**Interim Submission**  
**Pending resolution of issues associated with access to the**  
**Bay and Basin Leisure Centre precinct**

**SHOALHAVEN CITY COUNCIL**  
**ENVIRONMENTAL ASSESSMENT SUBMISSION TO THE NSW DEPARTMENT**  
**OF PLANNING**  
**PART 3A, ENVIRONMENTAL PLANNING & ASSESSMENT ACT, 1979**

**MAJOR PROJECT APPLICATION MP 06\_0205**  
**Modification No 2**

**PROPOSAL:** Proposed MP06\_0205 VDC Stage 1 - Modification No 2 being modification to the VDC Stage 1 approval by delivery of the VDC is two stages with Stage 1 now being approx 22,600m<sup>2</sup> and the future Stage 2, being approx 9400m<sup>2</sup> floor area, and associated arrangements; and the delivery of various off-site works before occupation of the VDC Stage 1.

File Path: C:\DOCUMENTS AND SETTINGS\PETERS.WY\DOCUMENTS\DRAWING.DWG
June 30, 2019 7:45:46 a.m.

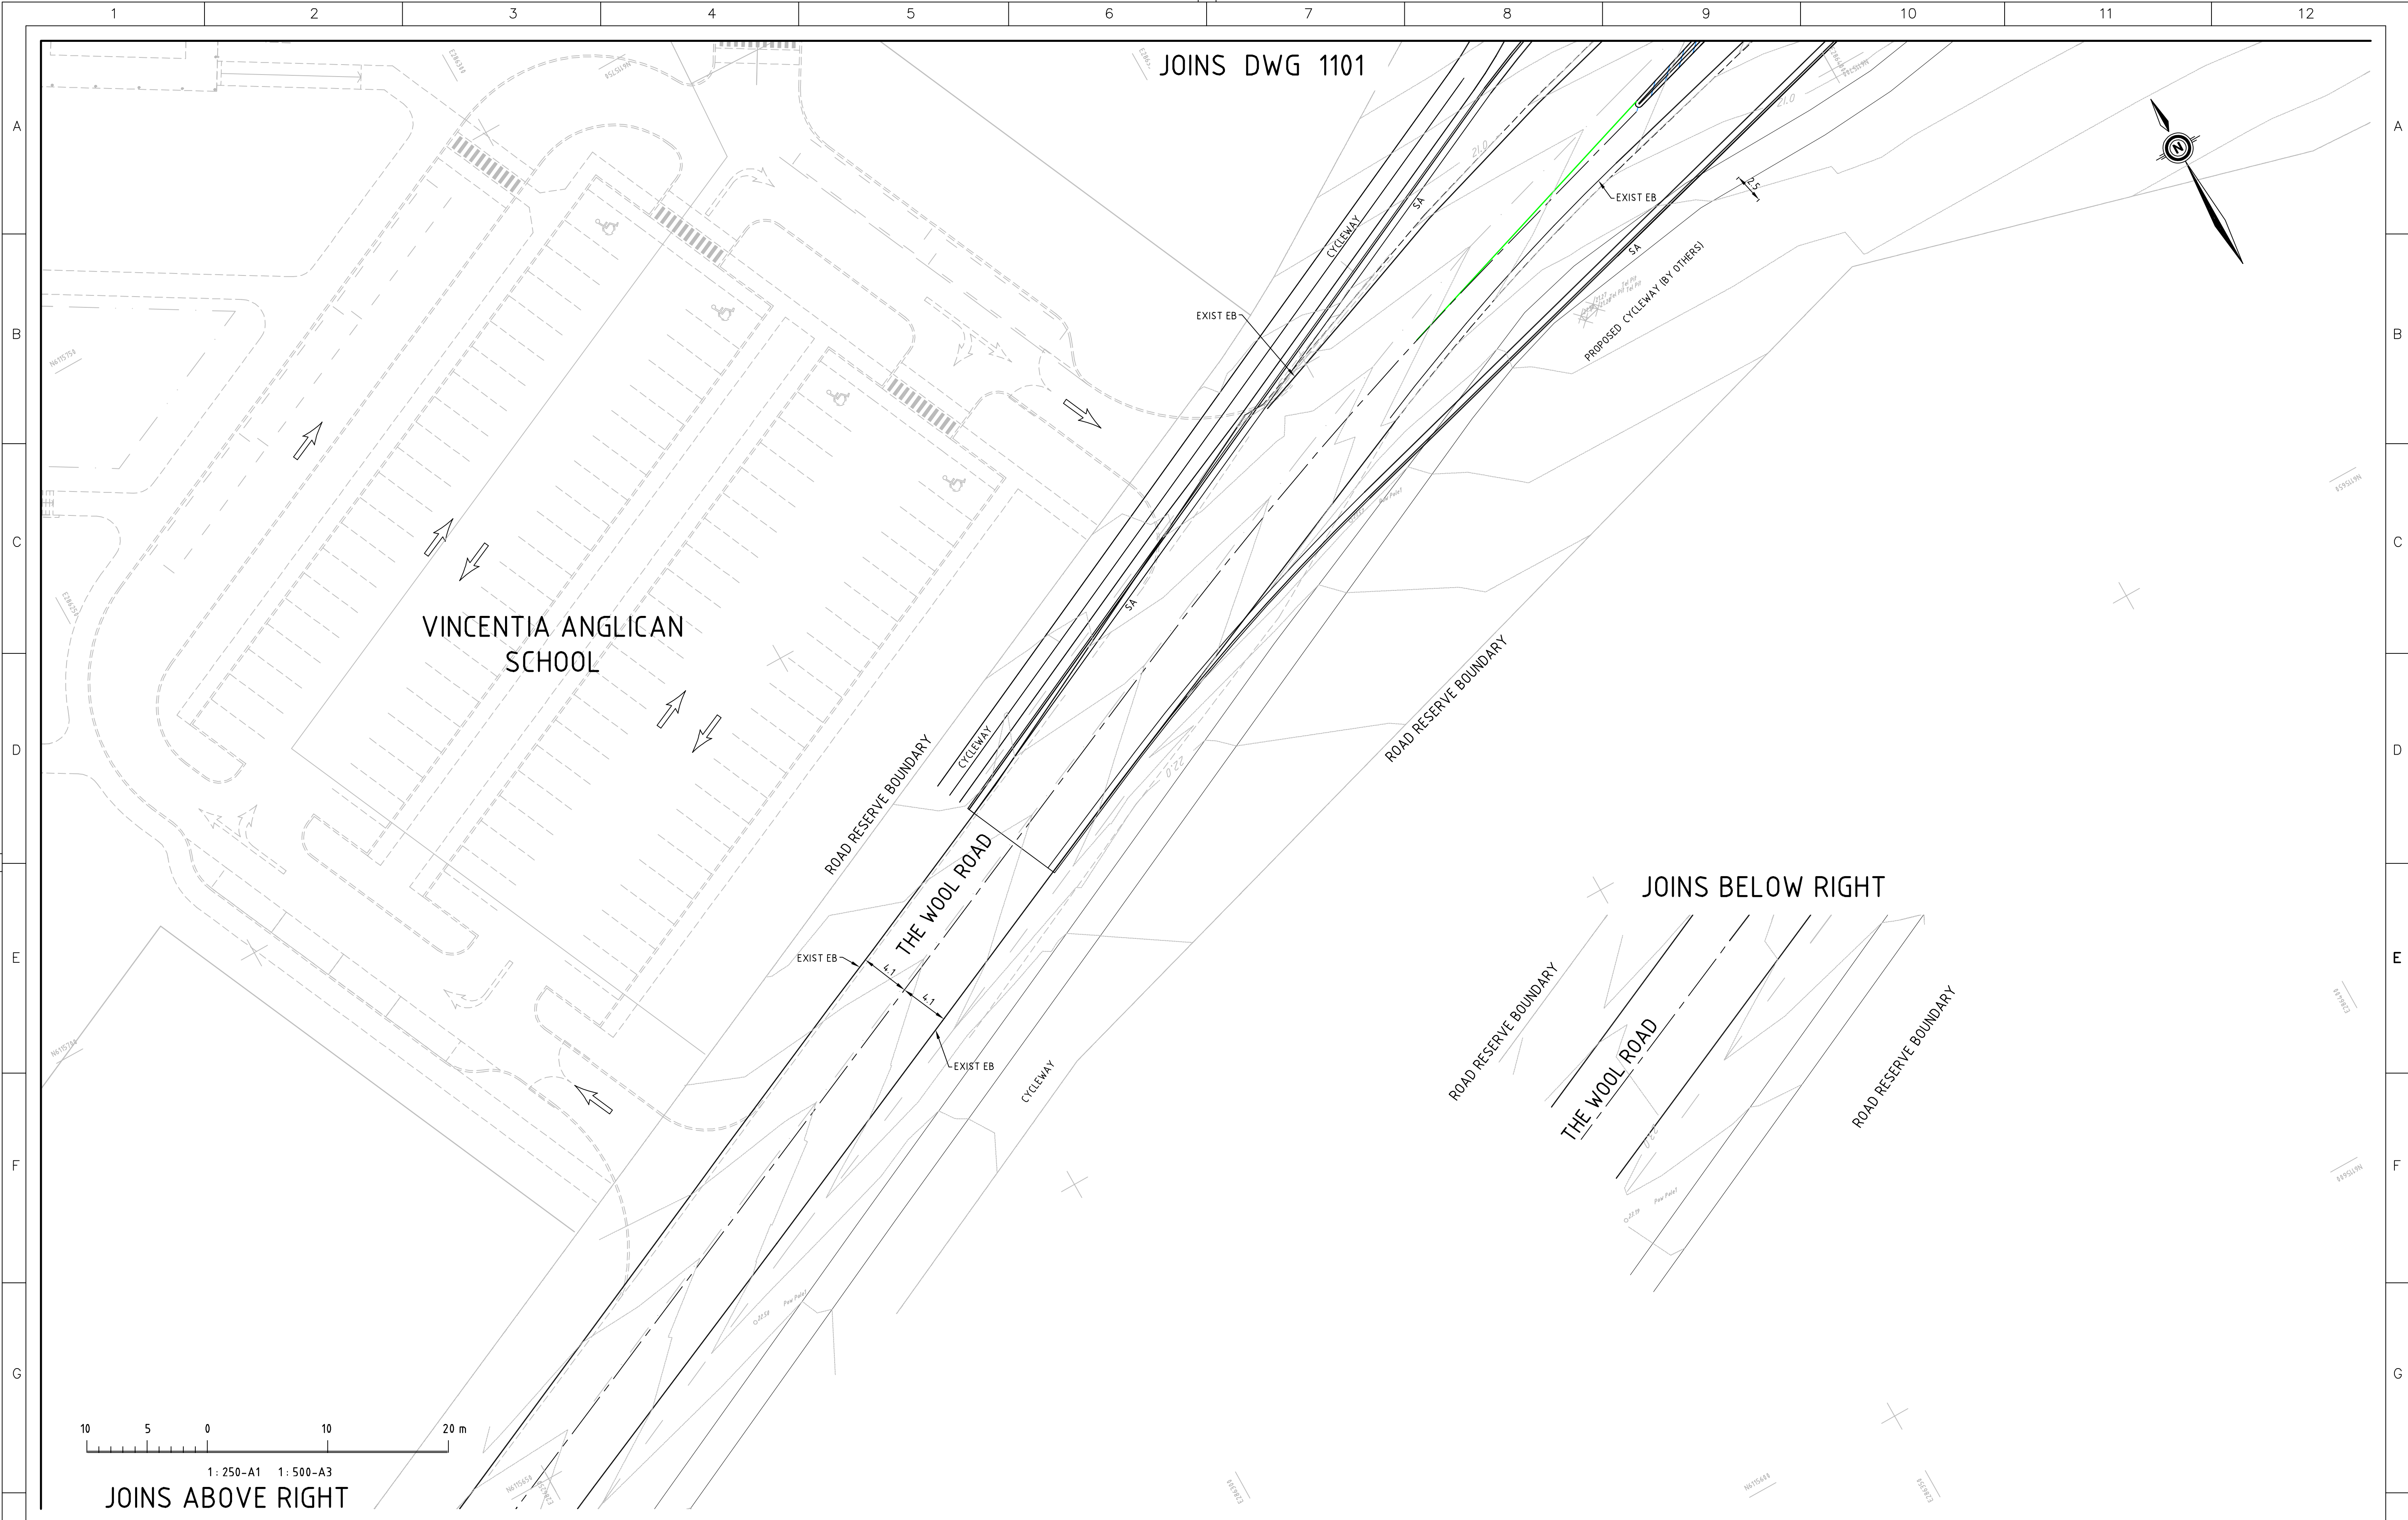
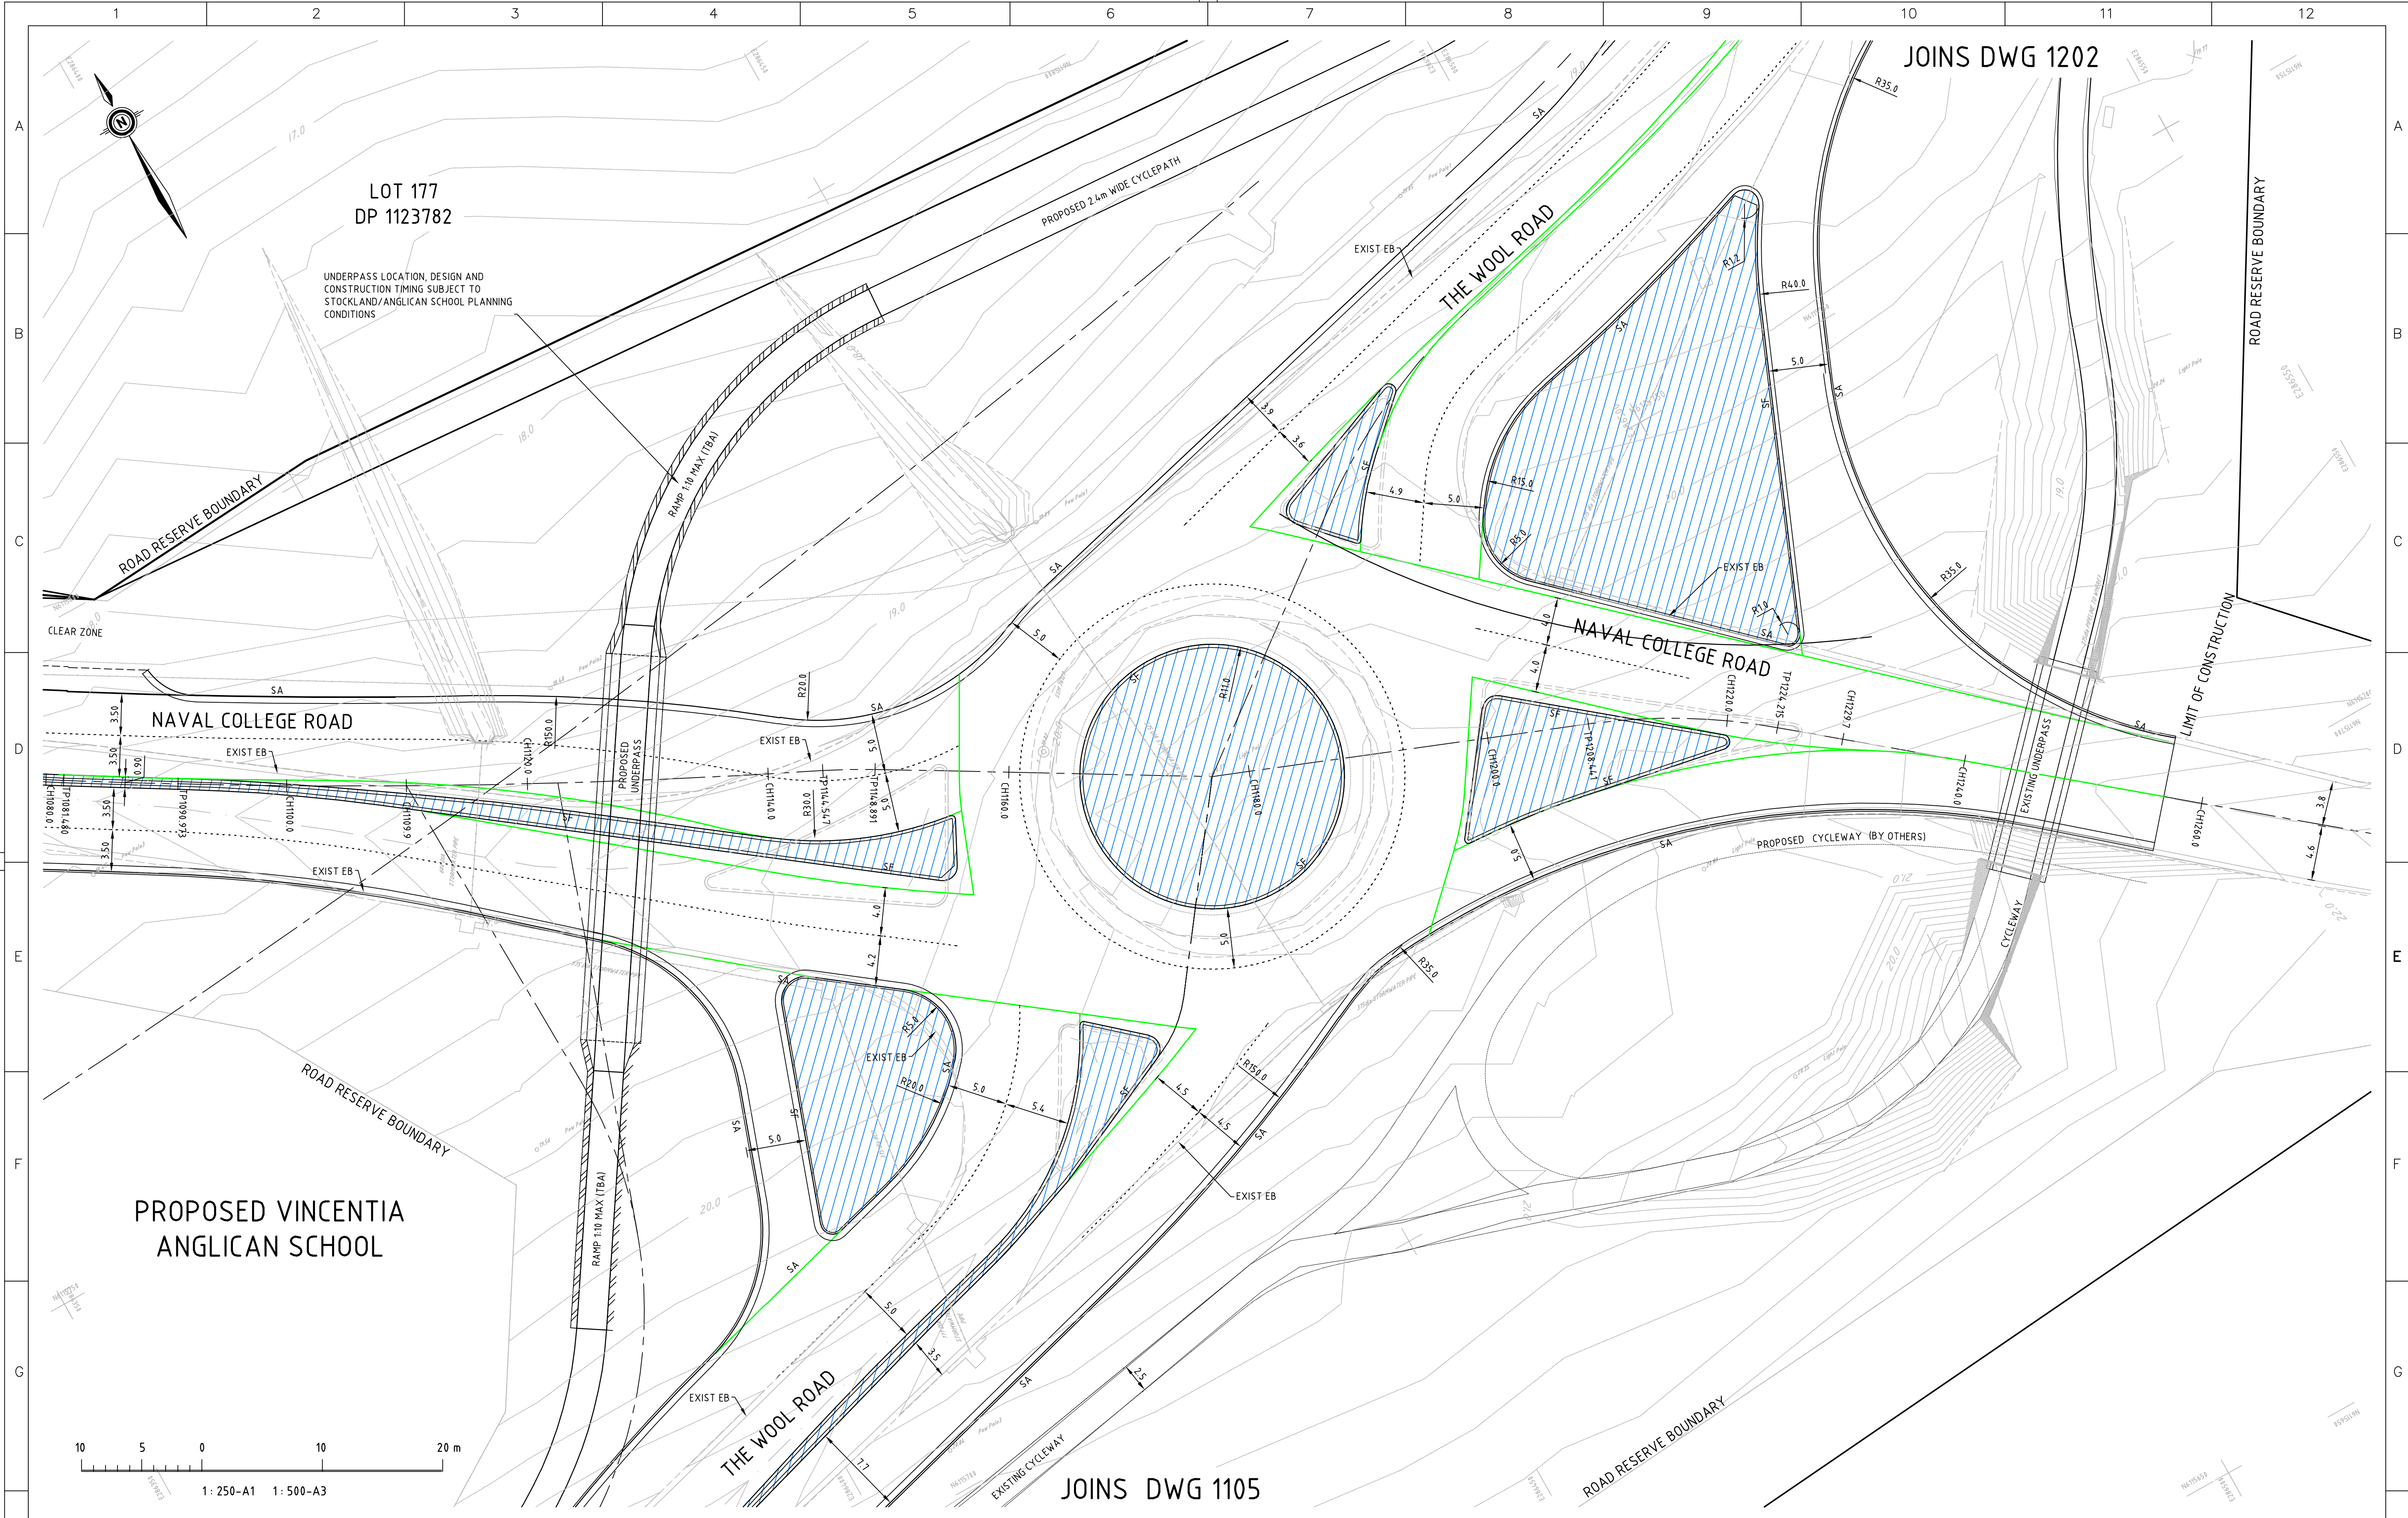
The design of a new road formation must take into account the constraints of the existing infrastructure in easements that exist and the final width necessary for two way movements and three lanes closer to the Wool Road ( similar to Cardno drawing 1010) will determine the reserve configuration. Council has provided comments on preliminary road designs that will be the subject of future consideration and referral to the Roads and Traffic Authority before determination and approvals are issued.
